EROSION CONTROL AND GRADING PLAN

SUPERSTAR CARWASH

MEADOWBROOK PKWY

E2.1

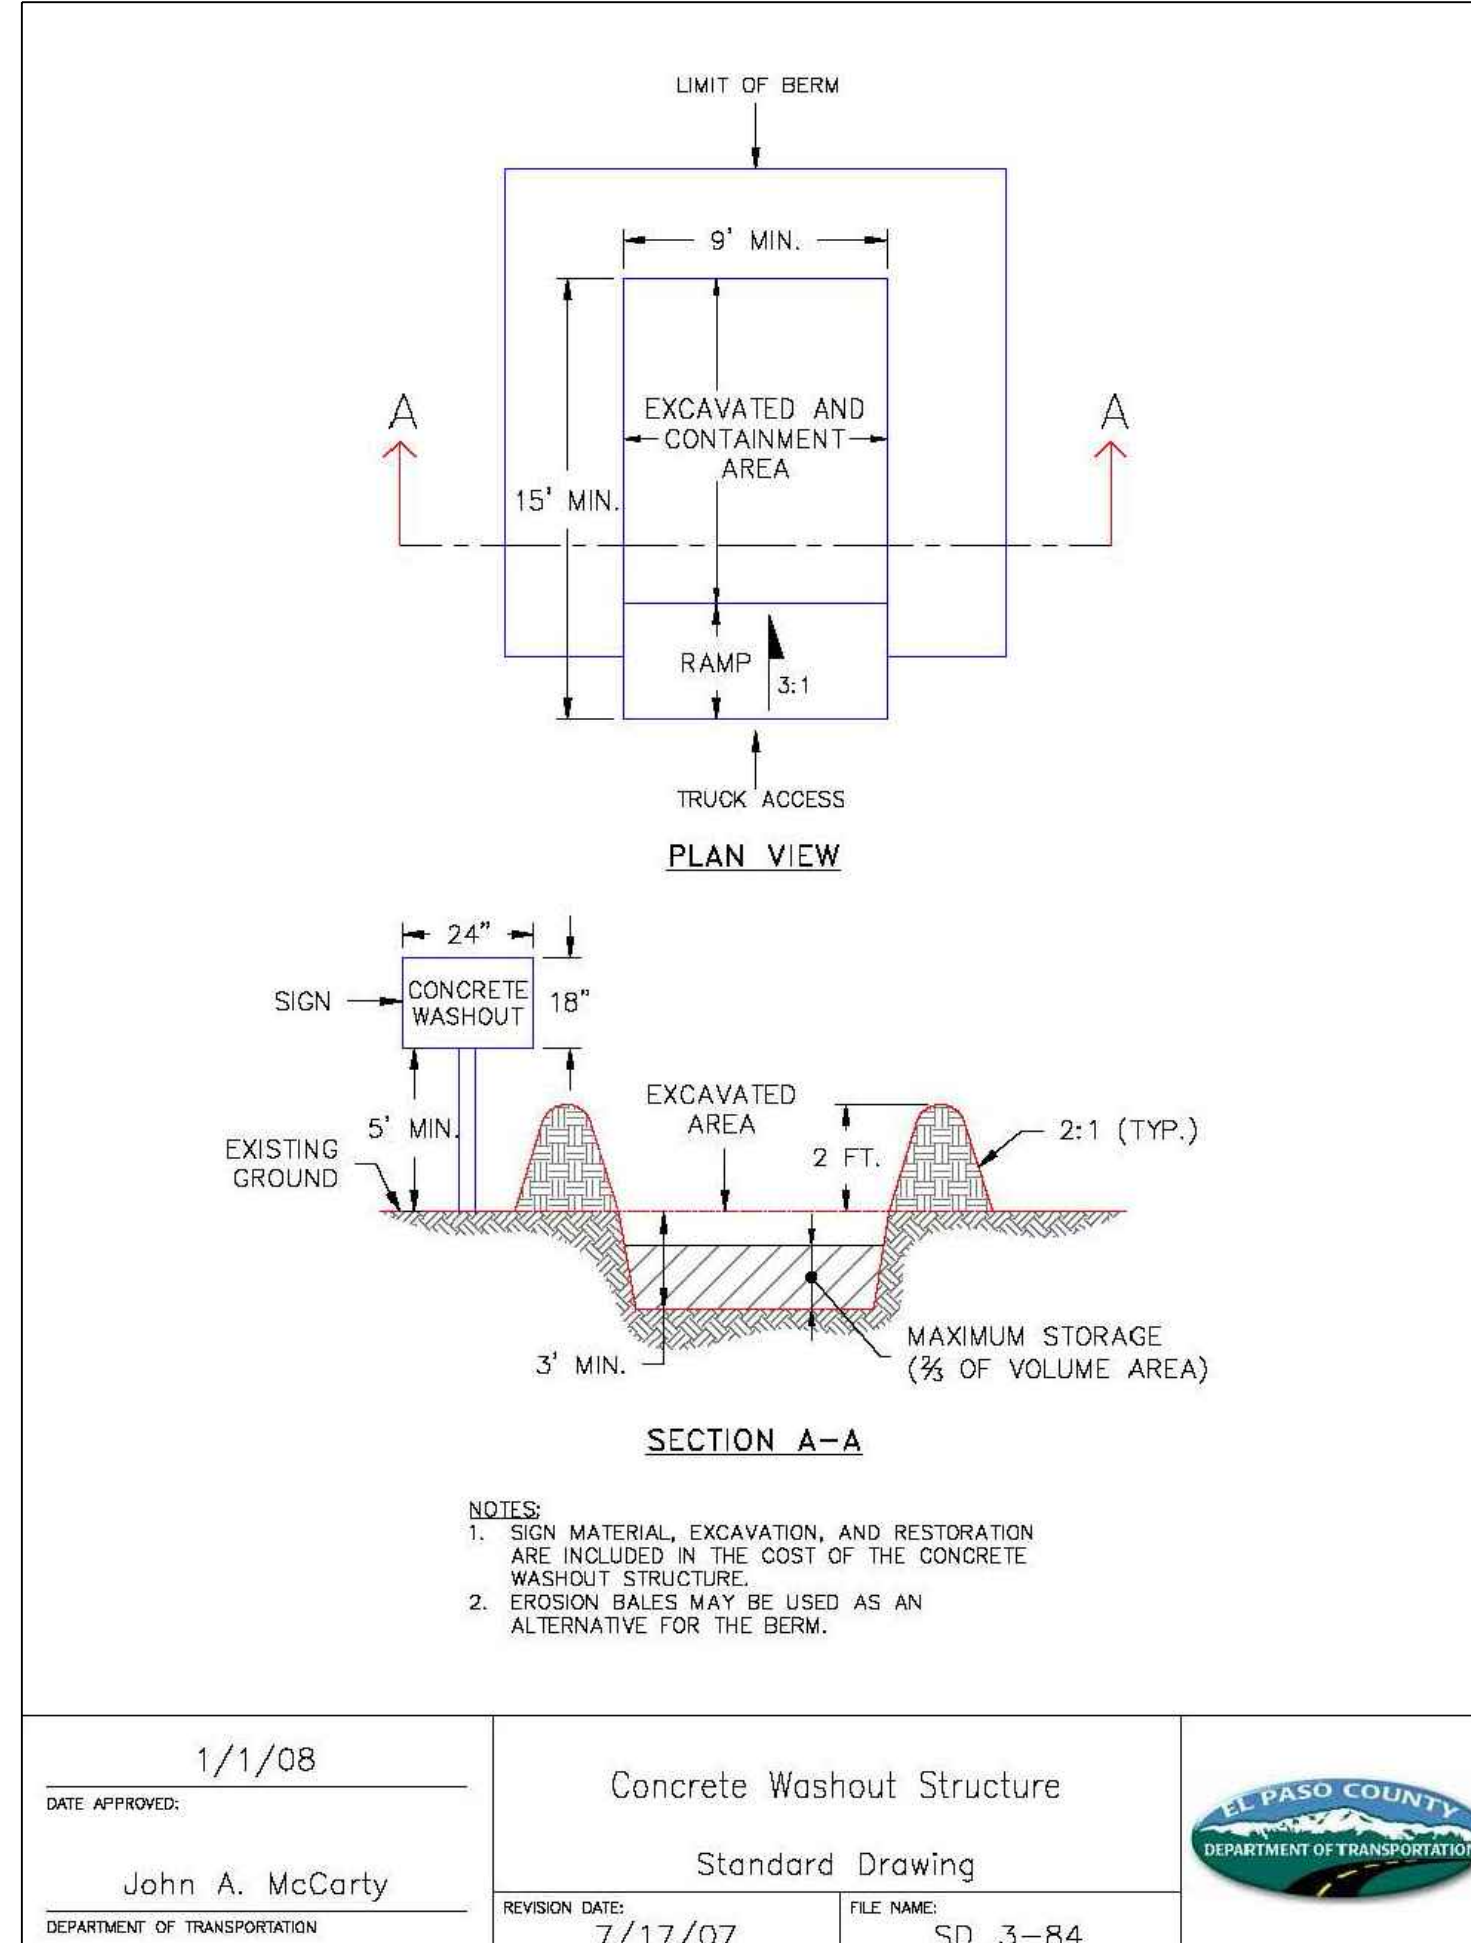
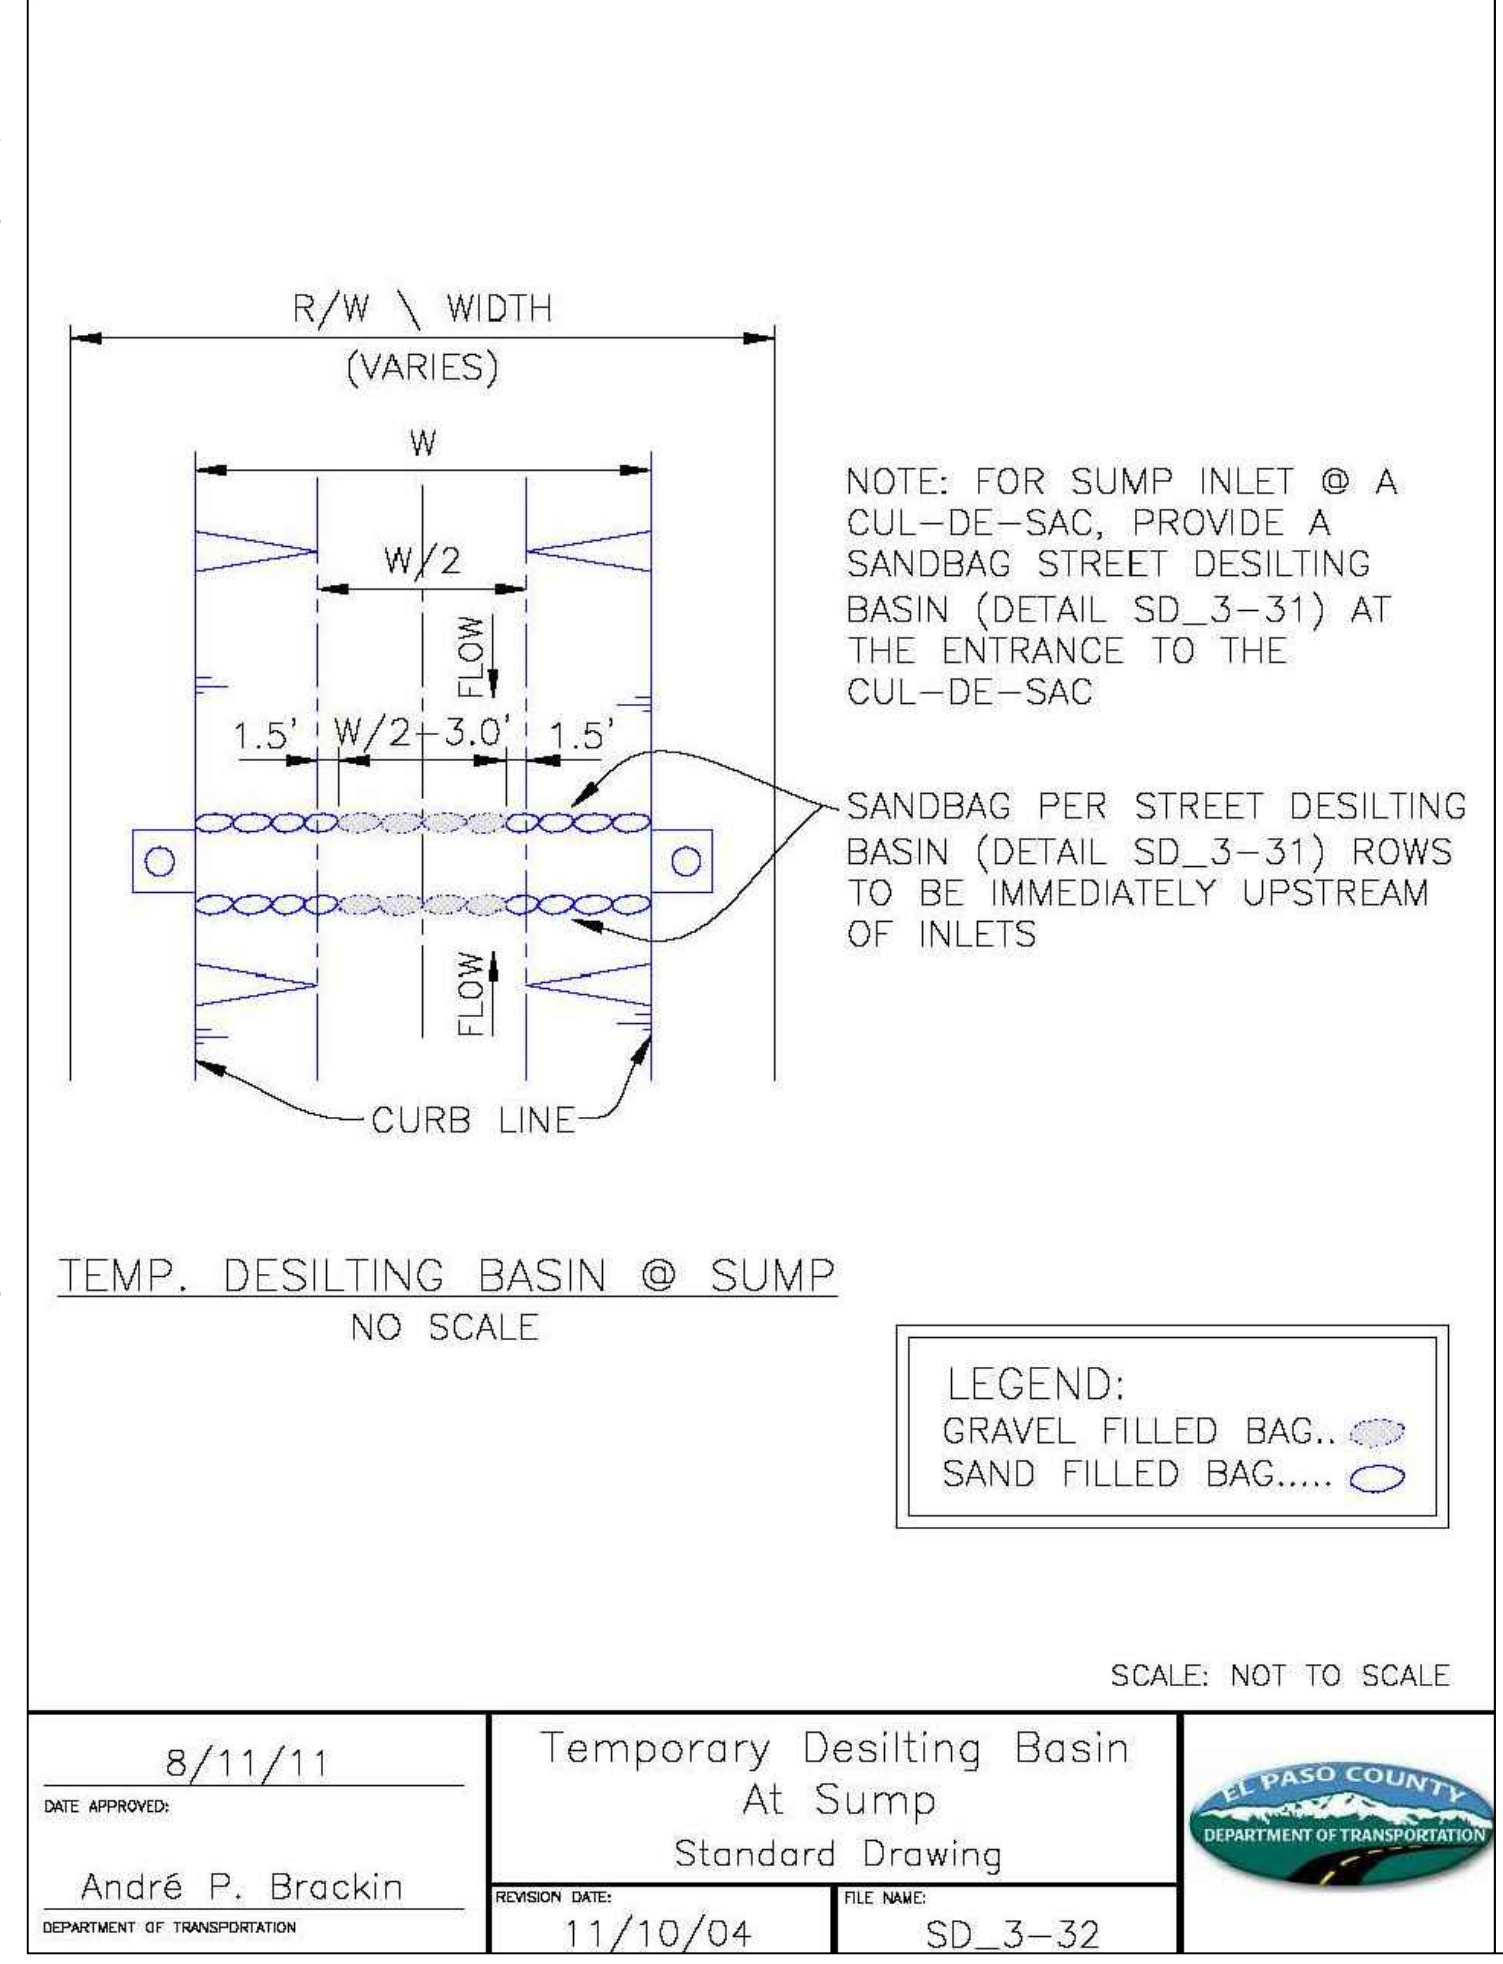
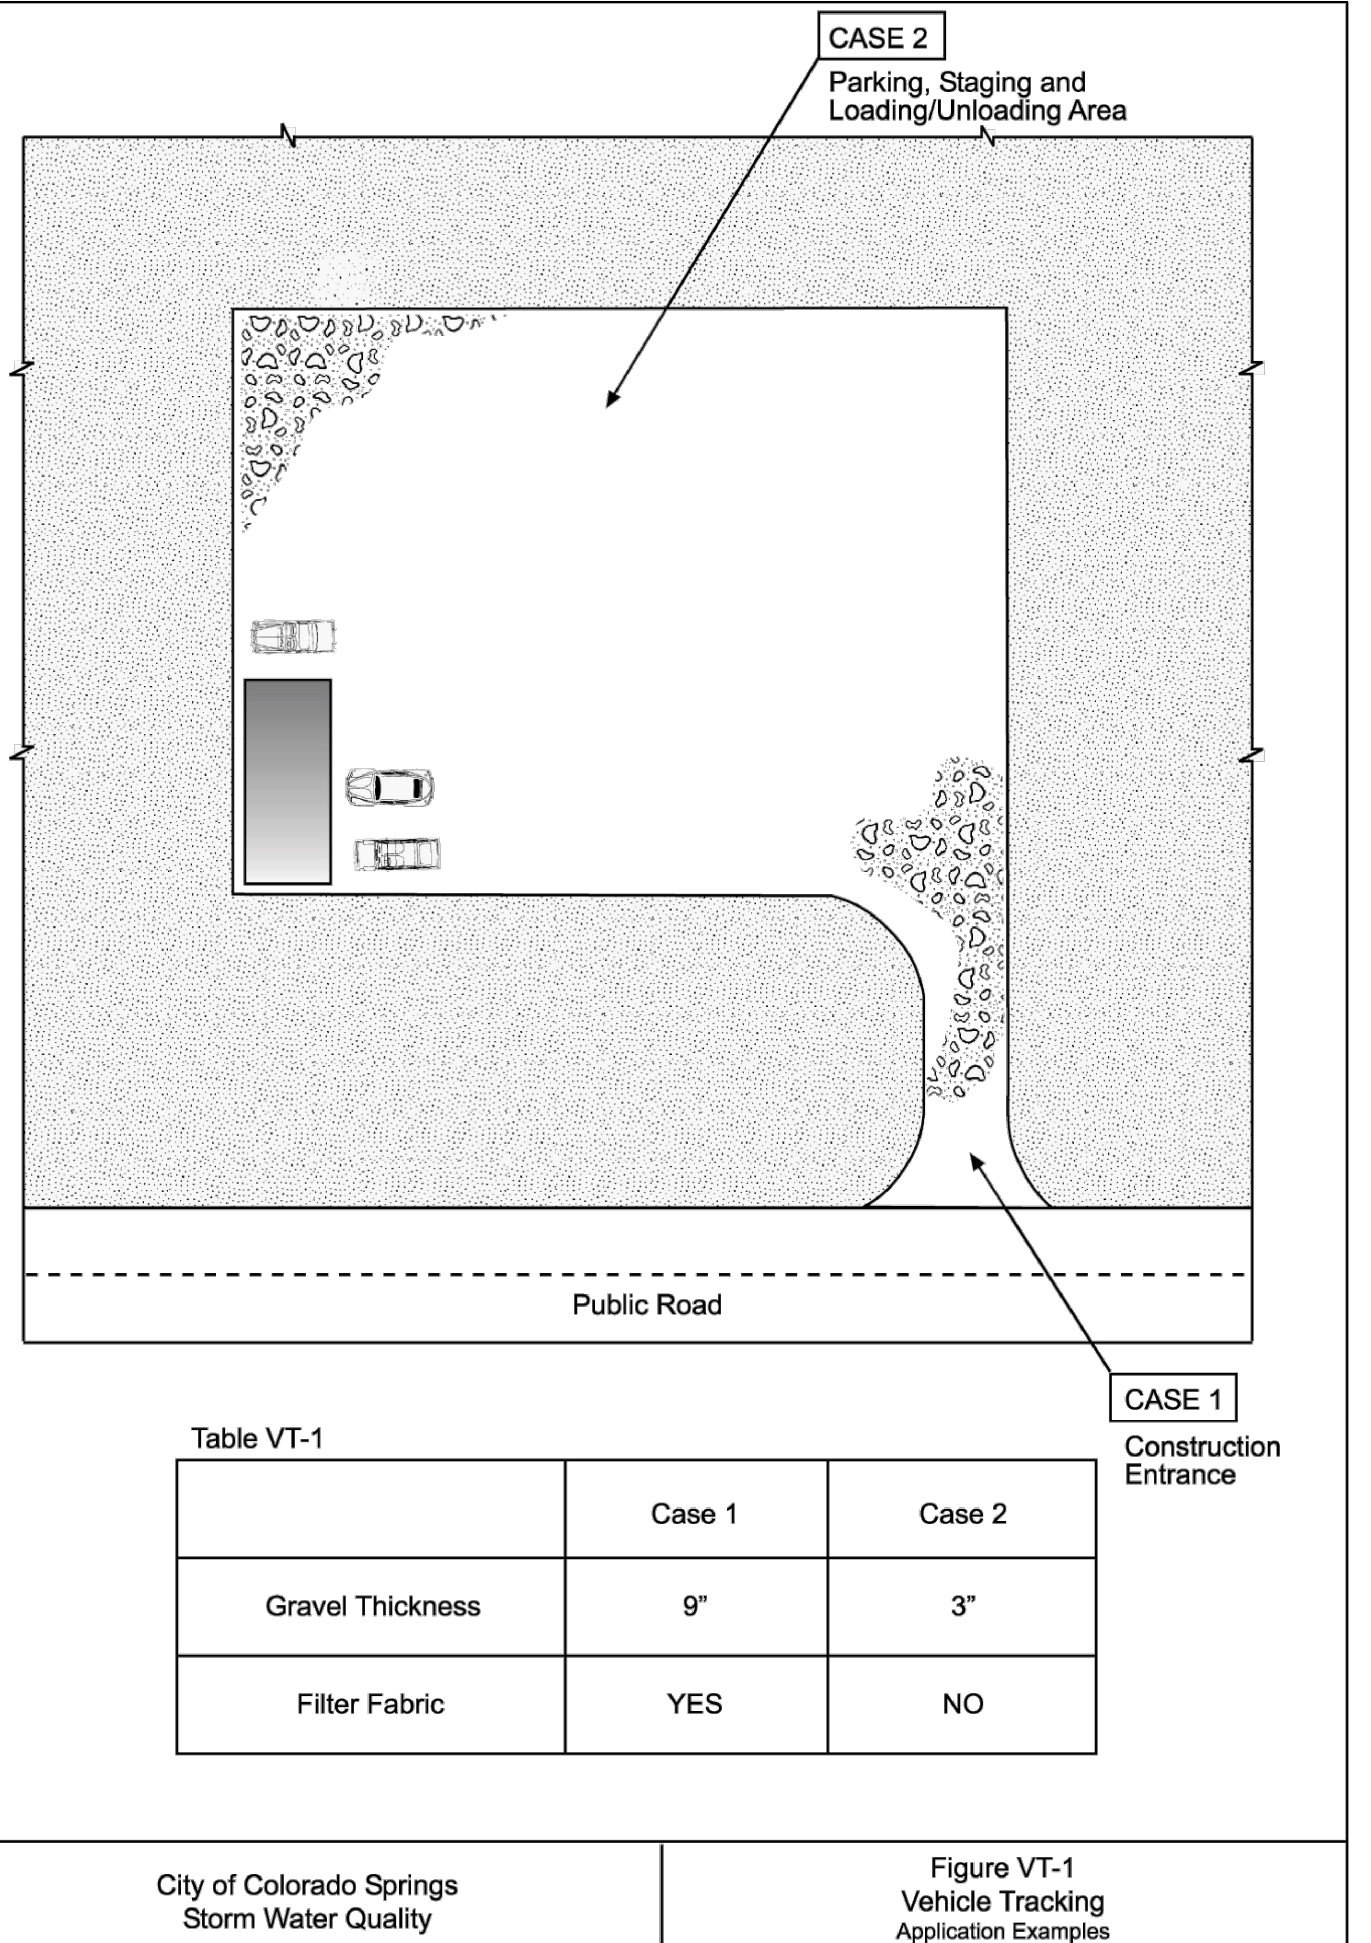
GEC Checklist item z:
-Add CWA detail.
-Add temporary sediment basin details.
-Add details for seeding and mulching.
-Add temporary soil stockpile BMP detail

this is for curb inlets. Provide detail for grate inlets
